AMENDMENT RECORD SHEET - POST DECISION

PLANNING AMENDMENT

H12/954/01/A1

PROPOSED MOBILE HOME
& PORTABLE OFFICE/ADMIN
UNIT.

AMENDED PLAN

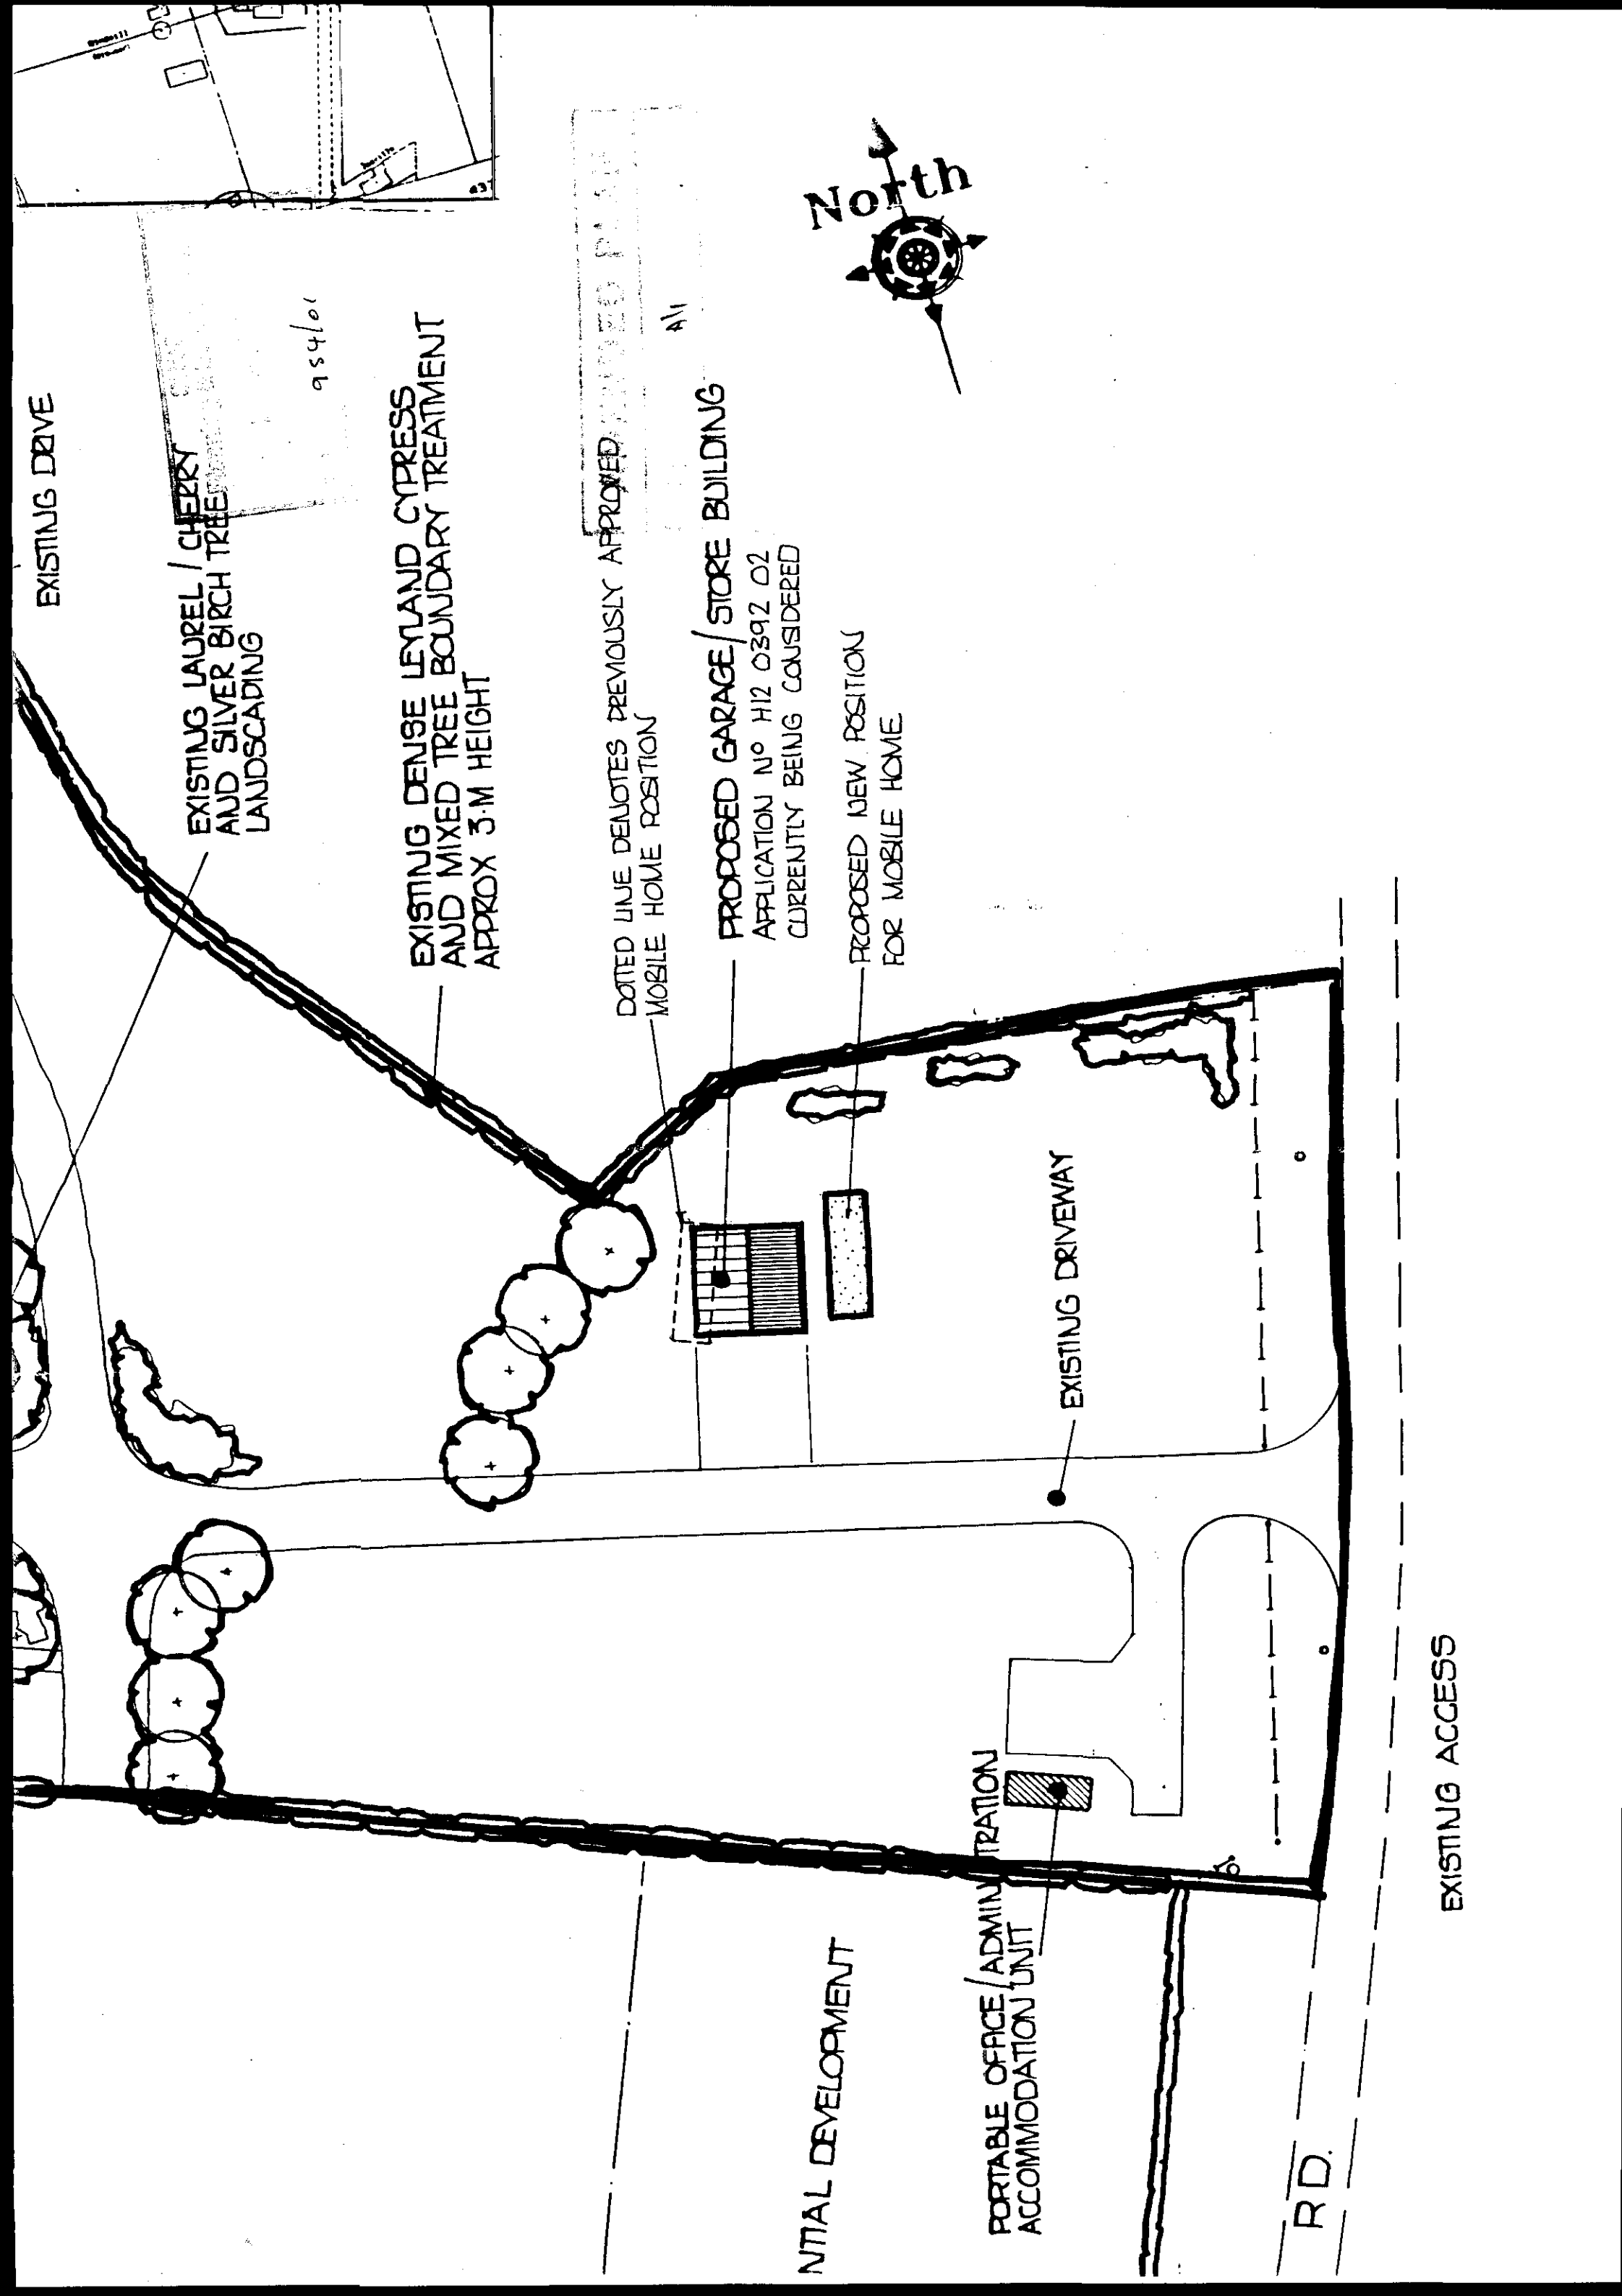
REPOSITION MOBILE HOME
